M5 Junction 10 Improvements Scheme

Statement of Common Ground
Environment Agency
TR010063 – APP 8.4

8.3 Statement of Common Ground Environment Agency

Figure 2-2 River Chelt bridge cross-section

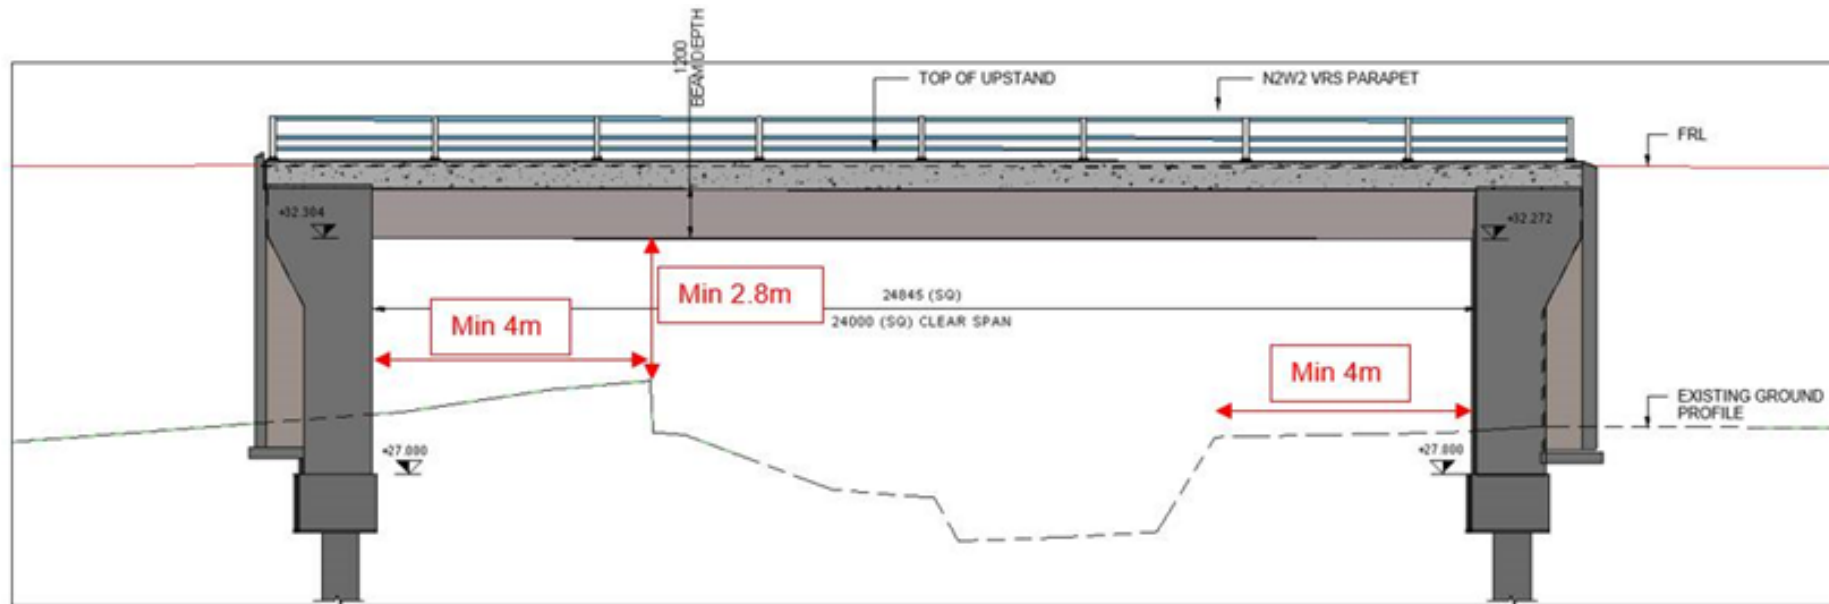
7.2.	<p>West Cheltenham Link Road River Chelt Bridge</p> <p>A single span structure is the preferred type of crossing to minimise impact on the water environment if designed appropriately. The EA welcome the clear span structure with no mid channel features with reduced interactions during the operational phase with the river bed and banks. However within the PEIR, there were conflicting descriptions of the geometry of the bridge in relation to the river. Whilst there will not be the direct permanent habitat loss and significant habitat severance associated with the culverting of the other watercourses there is potential for changes to riparian and associated flood plain quality and as well as water body hydromorphology leading to changes in river processes and habitats upstream and downstream.</p> <p>The Applicant has confirmed the structural dimensions of the proposed bridge (12.05.2022). The Applicant also acknowledged that based on indicative cross sections, the EA have requested greater variety in bank top to bank</p>	Matter agreed via EA review 07.06.2024.

Matter Reference number	Position	Date and method of agreement
	<p>top width to create a more geomorphologically interesting channel. At this time the drawings shared are concept plans and further work will be incorporated at that point to support detailed design (13.01.2023).</p> <p>At a meeting held on 05.06.2024, the Applicant confirmed that ref WE4 in the REAC details the geometry of the River Chelt bridge, therefore the EA are satisfied that there are no conflicting descriptions with regards to the bridge geometry. Refs WE3 to WE9 mentions measures to avoid deterioration to hydromorphology and ref WE15 states that works in the floodplain will be minimised as far as possible. Therefore, the EA are also satisfied that changes to riparian and flood plain quality and hydromorphology have been adequately addressed.</p>
